Re: Railway (Metrolink - Estuary to Charlemont via Dublin Airport) Order [2022]
Metrolink. Estuary through Swords, Dublin Airport, Ballymun, Glasnevin and City Centre to
Charlemont, Co. Dublin

Metrolink Order 2022 Estuary to Charlemont

**Seatown Villas Residents Submission
18/11/2022**

Project	Drawing Title	Drawing Status
Estuary - Seatown Landscape Layout Preliminary Design Issue		S4
Drawing N°	ML1-JAI-ARL-SC01_XX-DR-Y-00001	
Scales Original Size A1	1:1000	Sheet 1 of 3

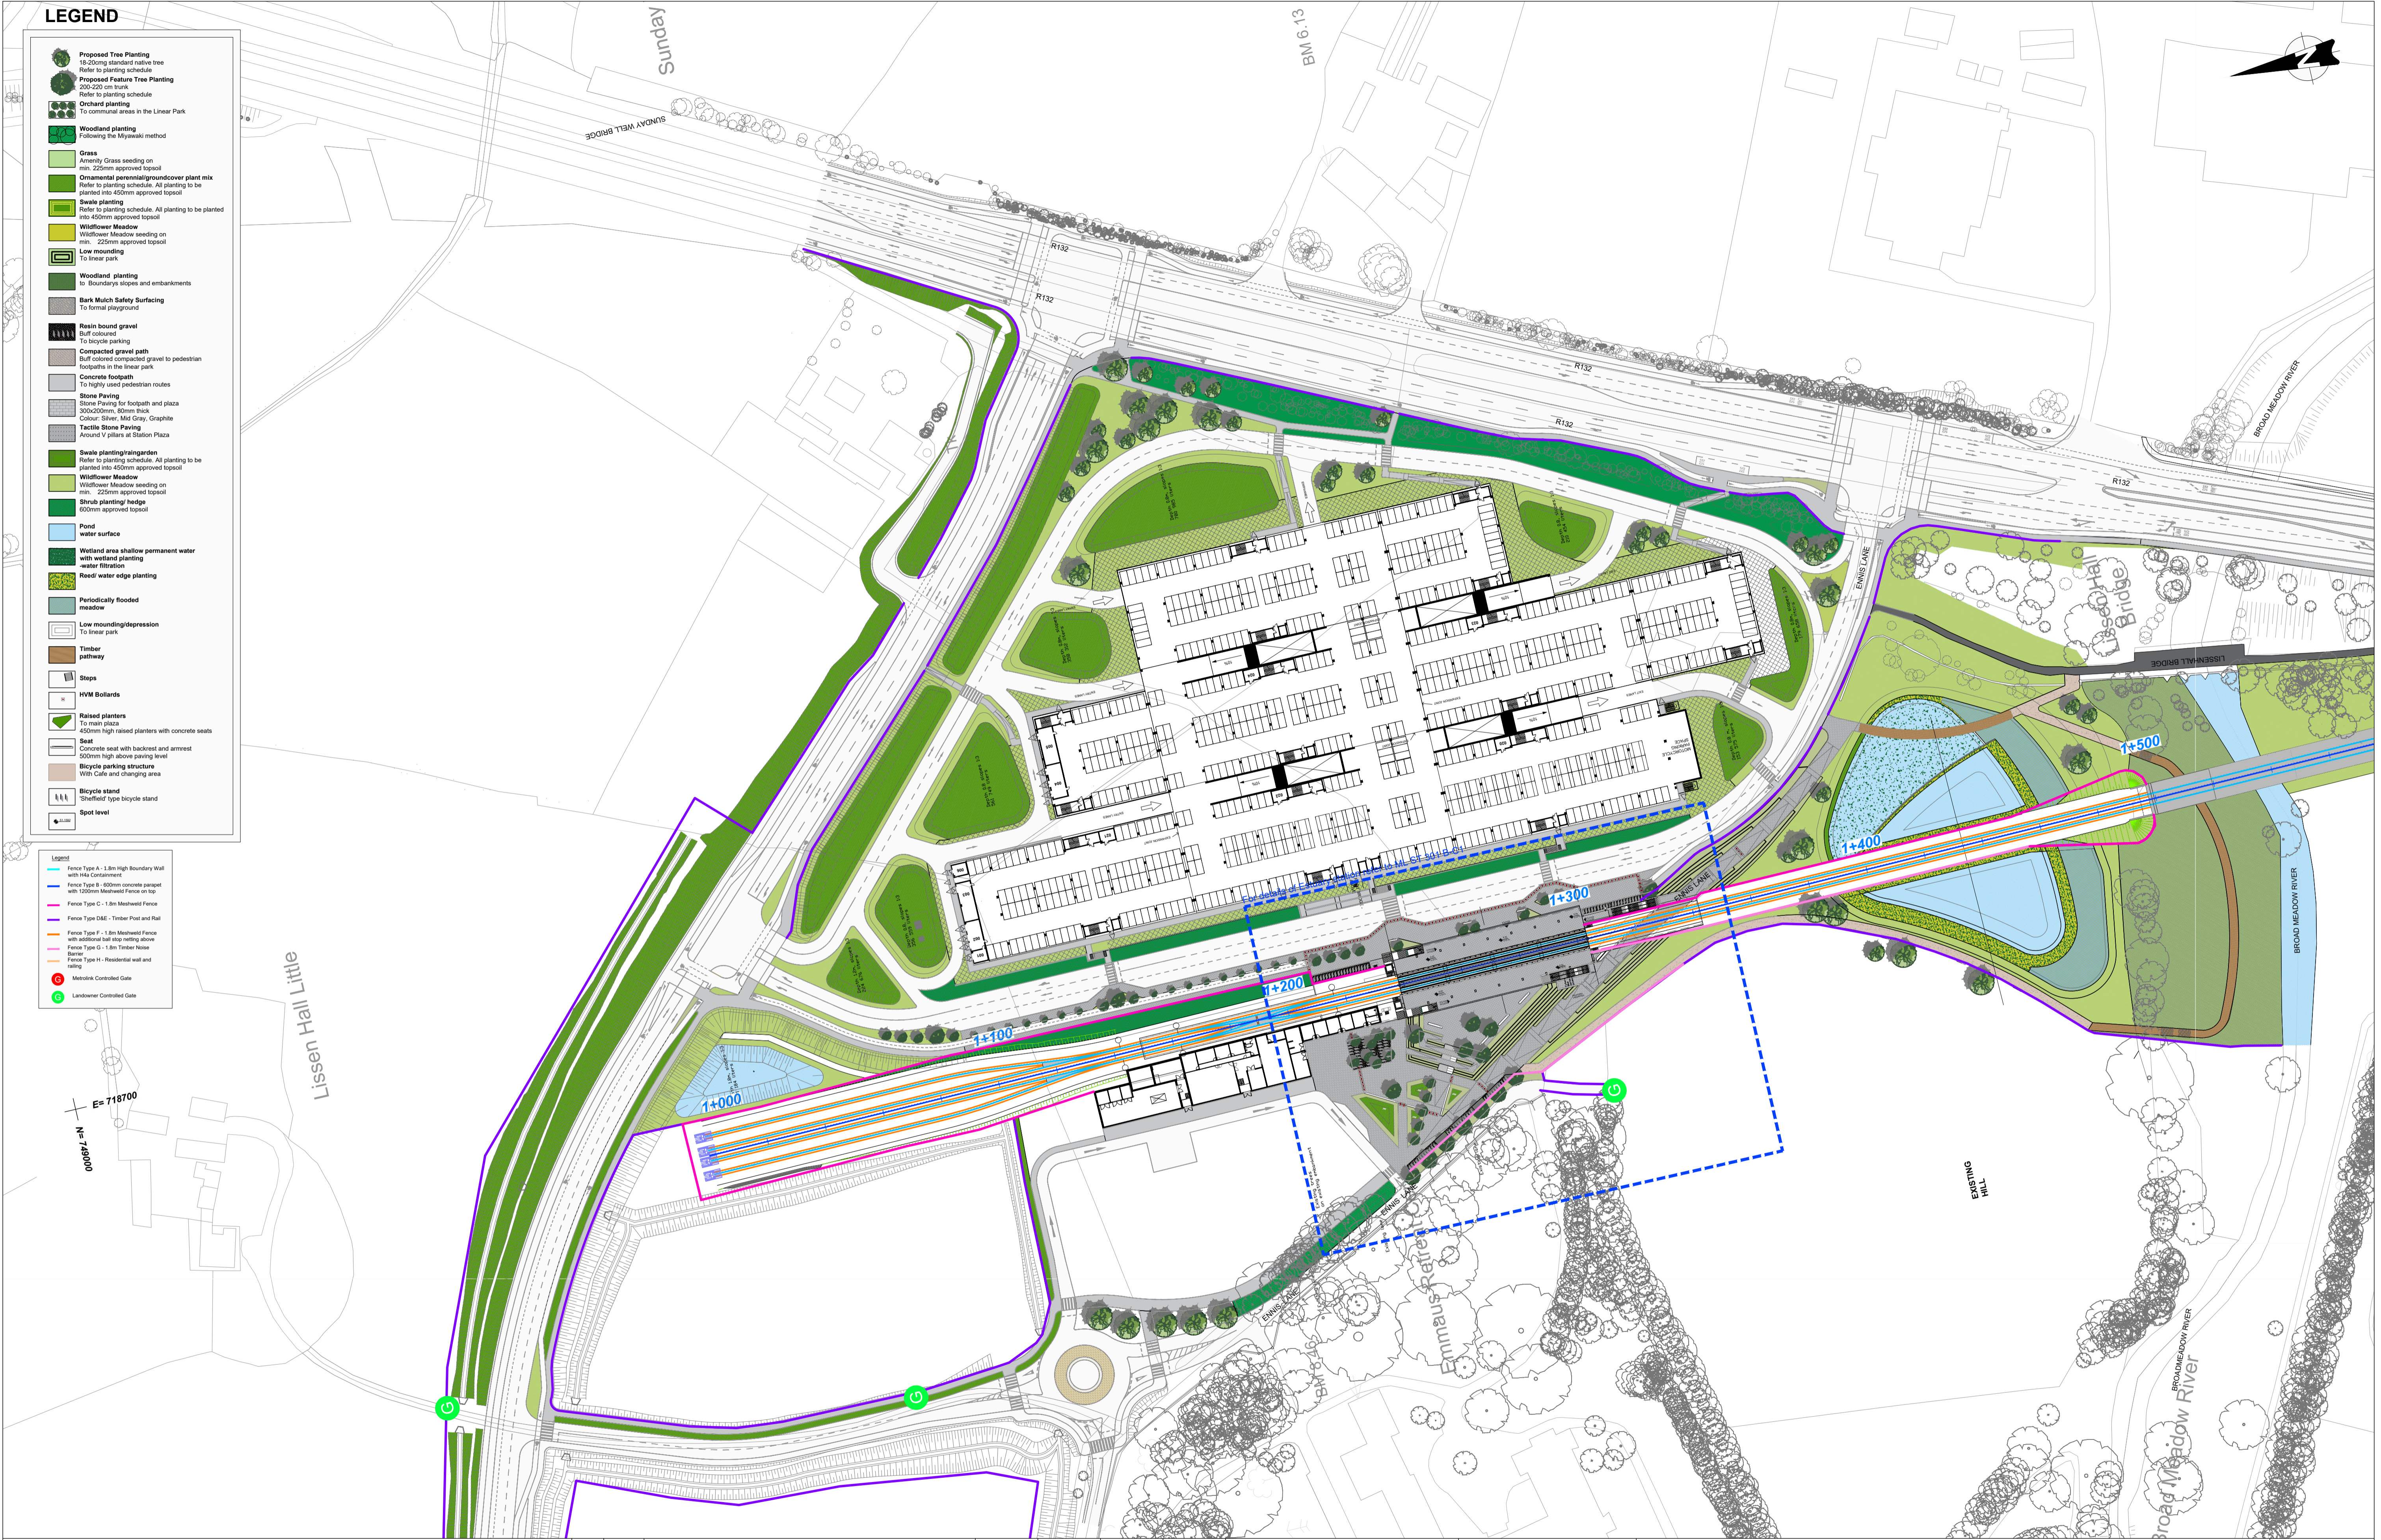
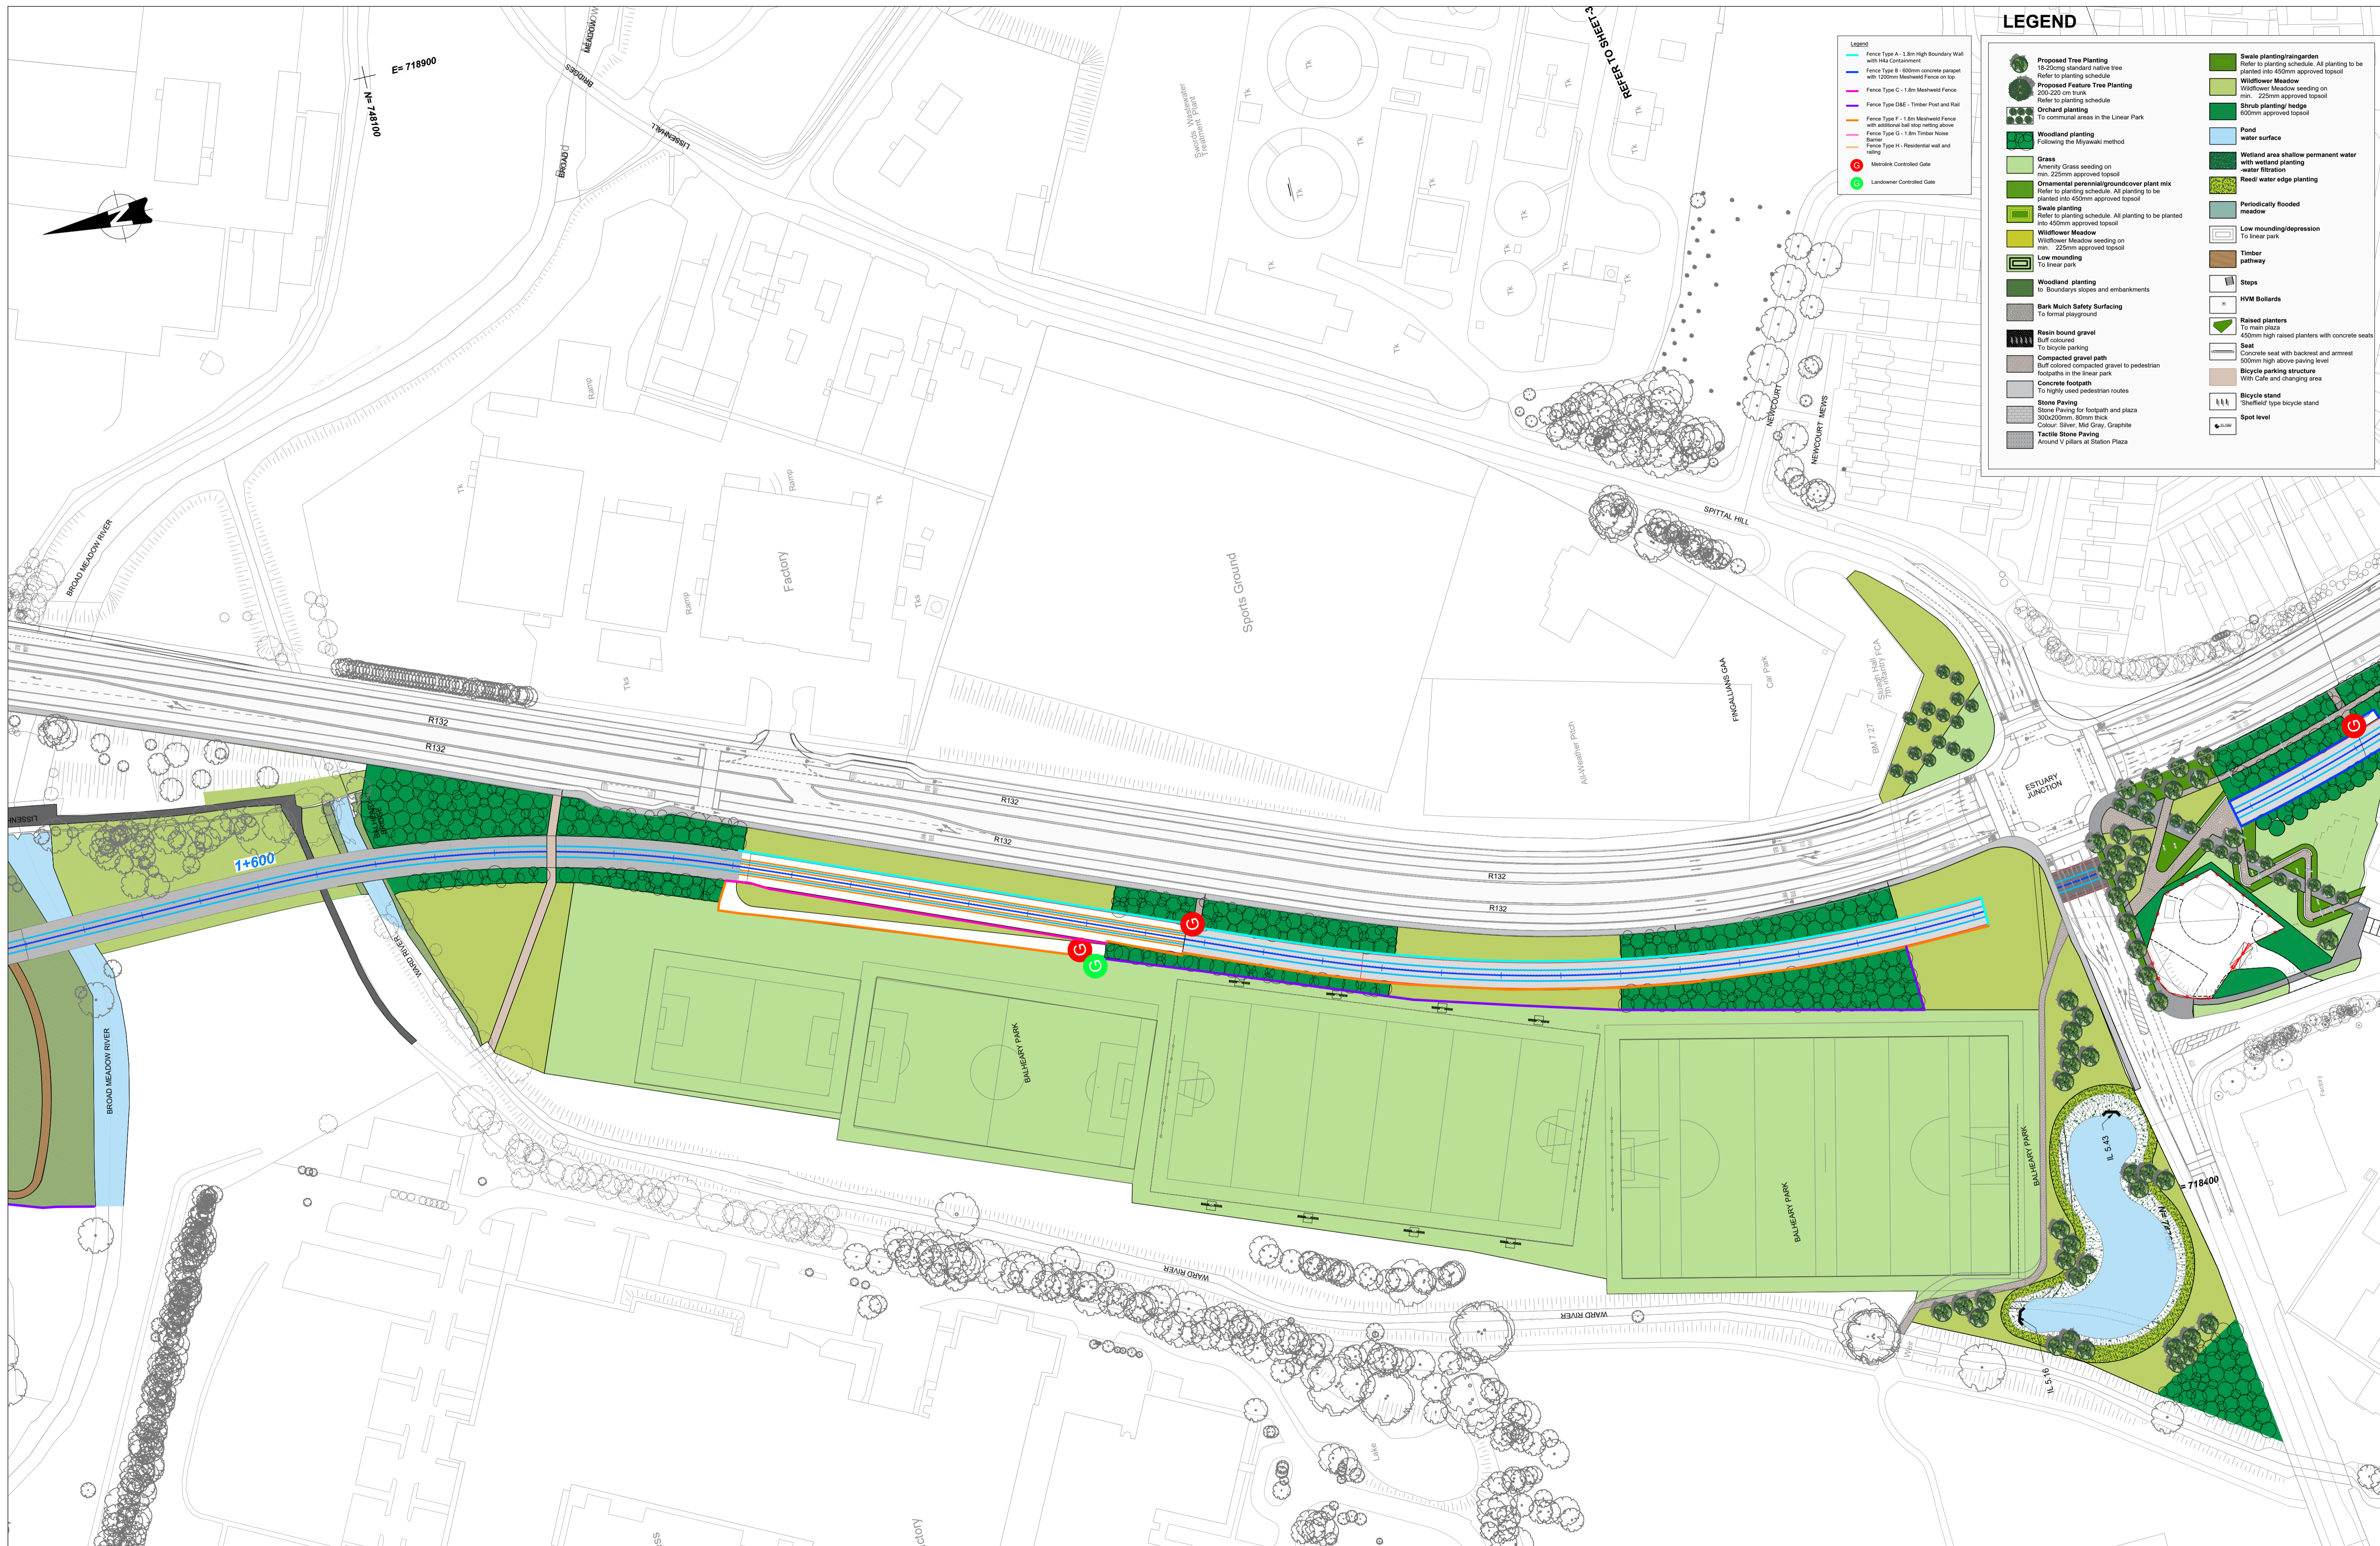
Seatown Residents along with Ashley Estate and Estuary Court have serious concerns with the design and the need for penetrations into our estates through the existing substantial walls that presently separate our green from the very busy R132 road .

The Proposed Pedestrian Foot paths into Seatown Villas do not serve to shorten the journey to the station from any direction with the exception of the residents of Seatown Villas.

Seatown Villas already has 4 pedestrian entry points into the estate at present and we believe the proposed extra pathways for the linear park will .

- Have the potential to endanger our children playing on our greens as there is access from the motorway so they could easily get on the R132
- Easy access/ egress from the R132 to our estate which will not have any obvious positive impact on our lives .
- Anti- social behaviour - due to the opening up of the estate with these new pedestrian routes .TII have even proposed CCTV in this area which would form the opinion that they have already come to the same conclusion.
- Loss of identity as a community as our green area will become an open area and the estate will be just another " rat run"
- The paths we believe will encourage the parking of cars in the estate for people using the Metro when we as residents are already struggling for parking spaces in our estate.

TII intend to take our green spaces away over for 7+ years and then hand it back with paths through it and easy access to what is effectively a motorway .

1. Carry out a complete re-assessment of the alignment of the proposed routing considering the median R132 option properly along with the R132 upgrade programme.
2. Restore the walls and vegetation to and 'as was ' condition after the project
3. Not place any pathways in our green spaces or any penetrations whatsoever in our boundary walls
4. Completely cover over the open cut section of track
5. Look at other alternatives for site compounds instead of our green area.
6. Do complete assessment of a bored tunnel option.
7. Reinstate the footbridges after the construction works are complete.
